**PLAN:** Detached ADU Building  
 11235 S Holmes Rd, Unit B  
 Colorado Springs, CO  
 Schedule #: 5219000038  
 Zone: RR-5  
 Legal: Meets and Bounds TRACT N 25W44W OF COLORADO SPRINGS, EL PASO COUNTY, COLORADO

# Floor Plans.pdf Markup Summary

**MAIN LEVEL FLOOR PLAN**  
815 SQ FT HABITABLE AREA

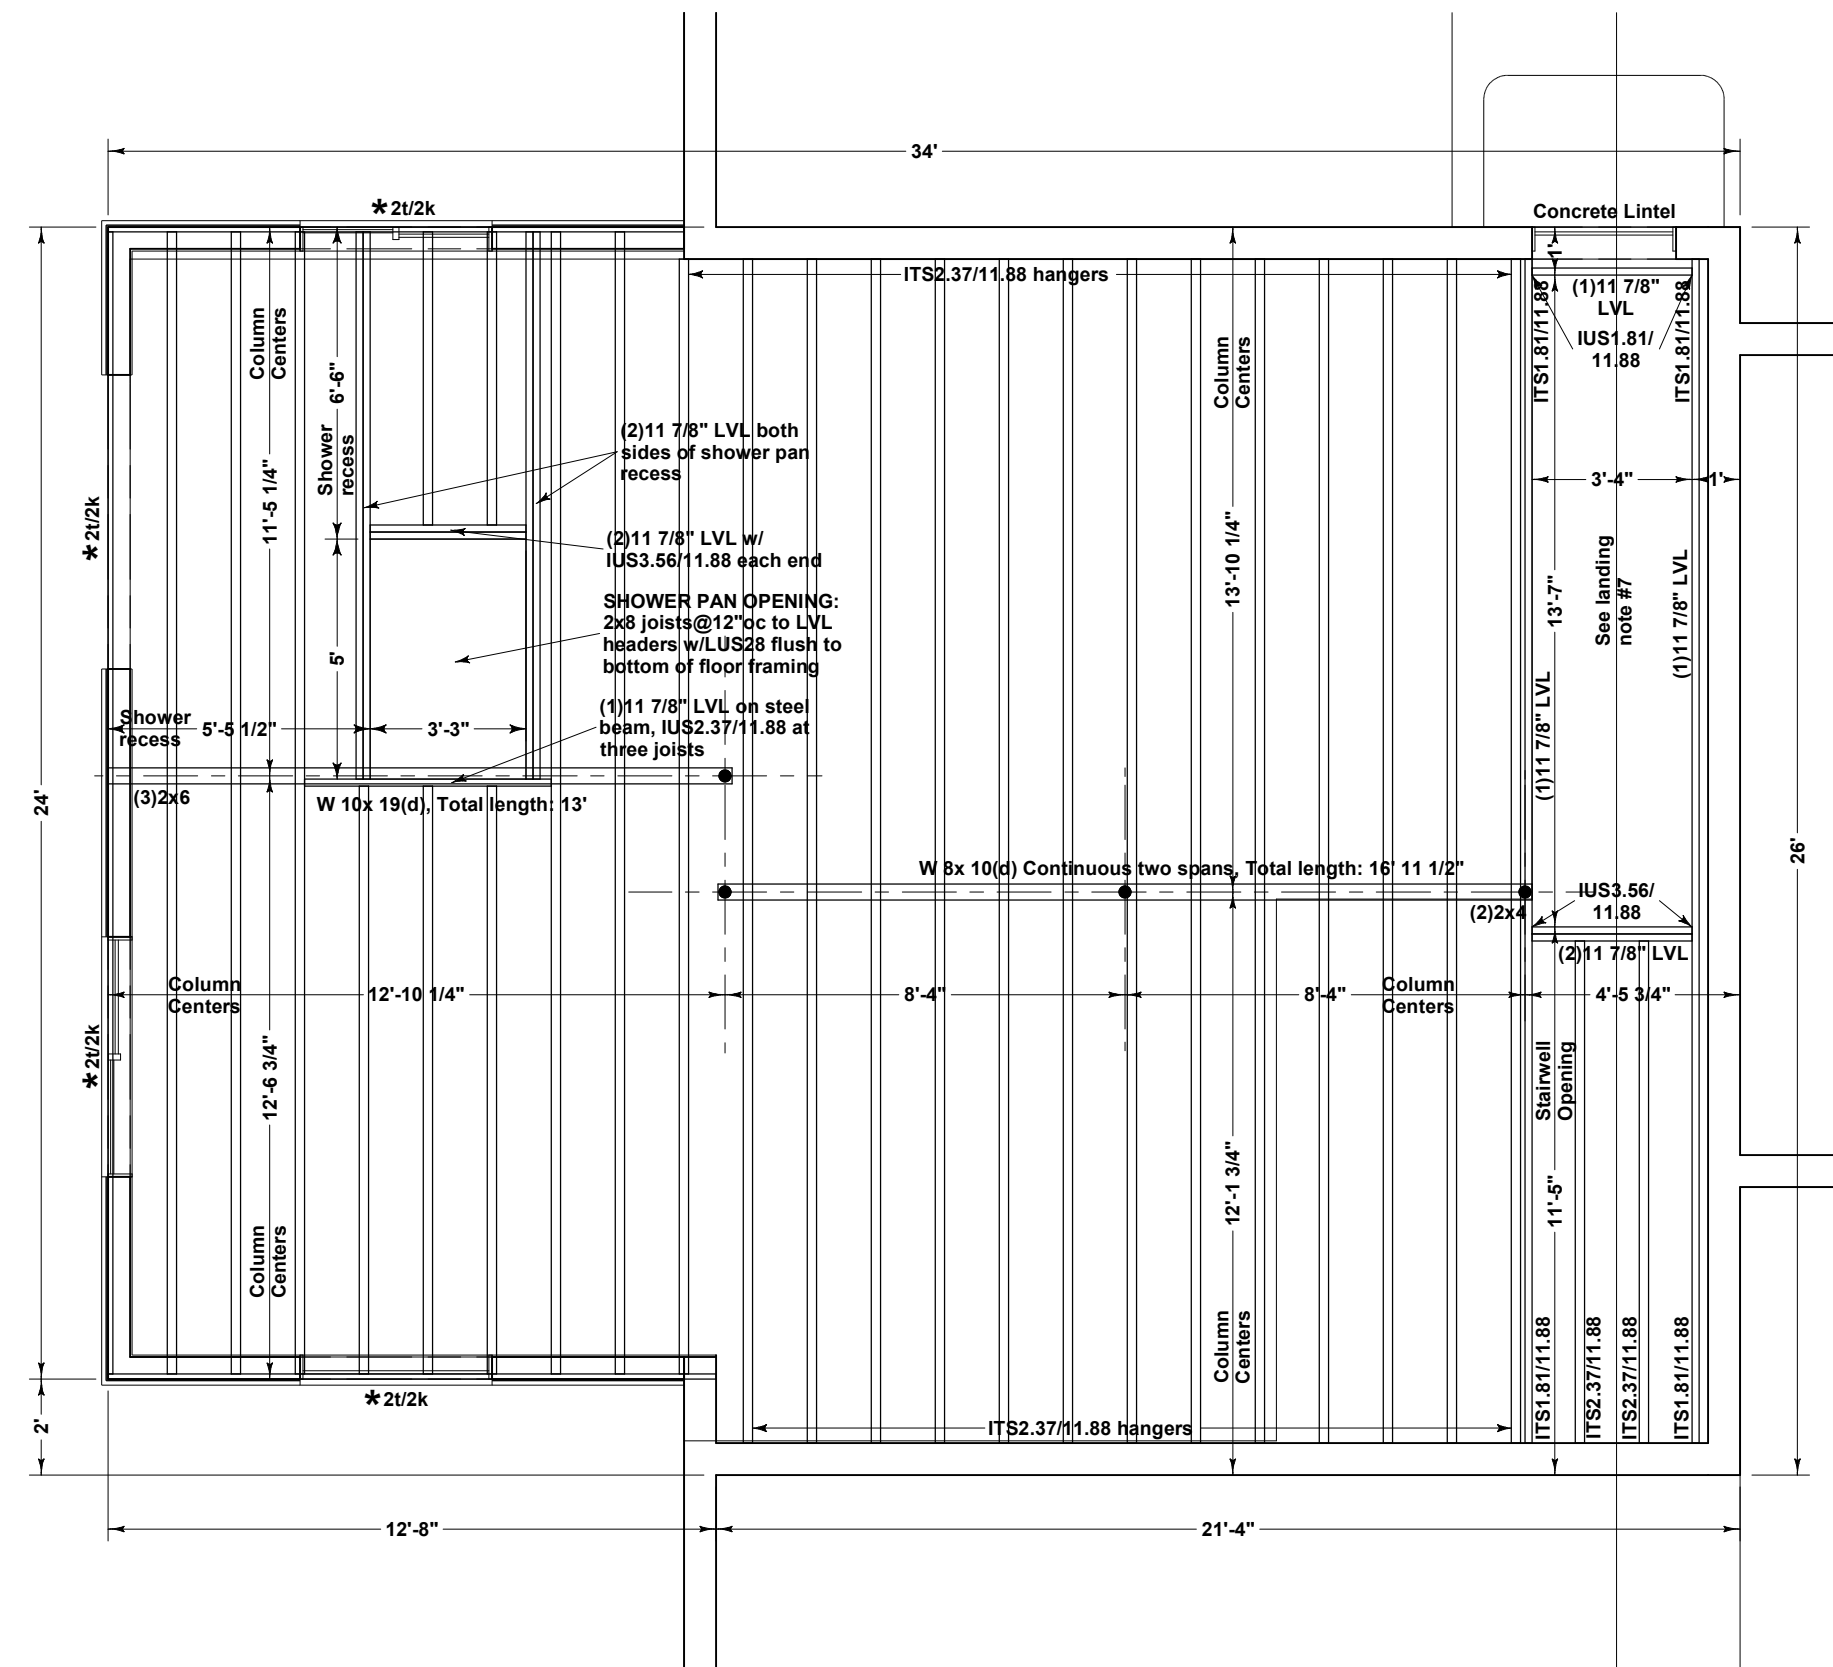
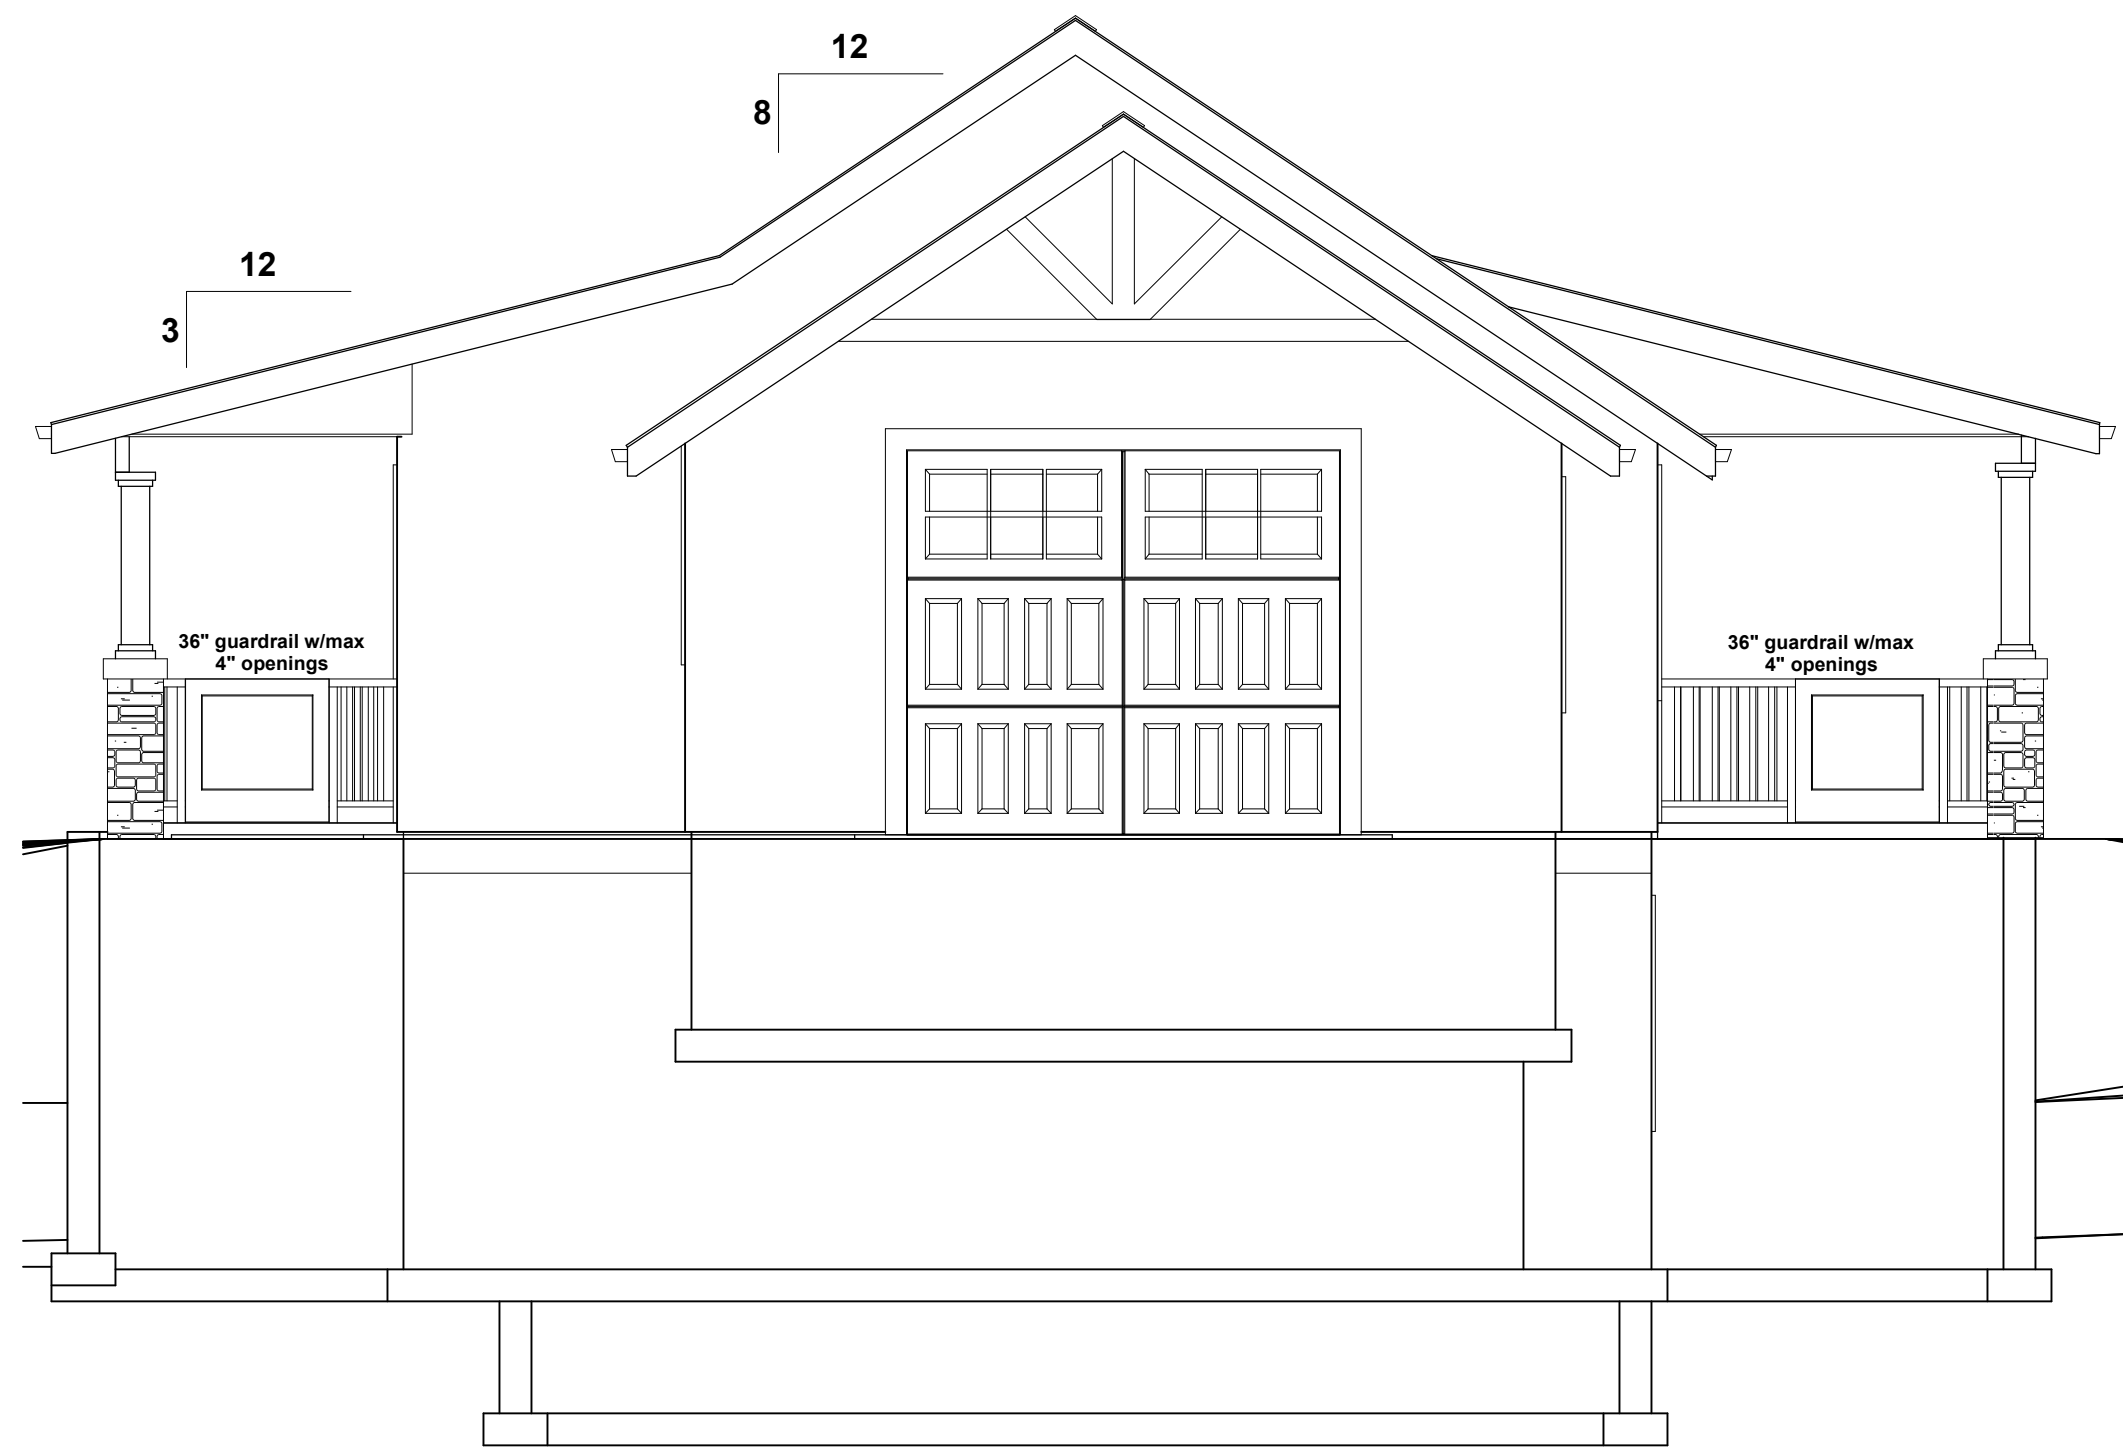
Please revise the floorplan / ADU/ALQ floor area square footage to report habitable area versus overall floor area. Habitable floor area cannot exceed 1,500 SF.

Please refer to the comment on Site Plan drawing for more information.
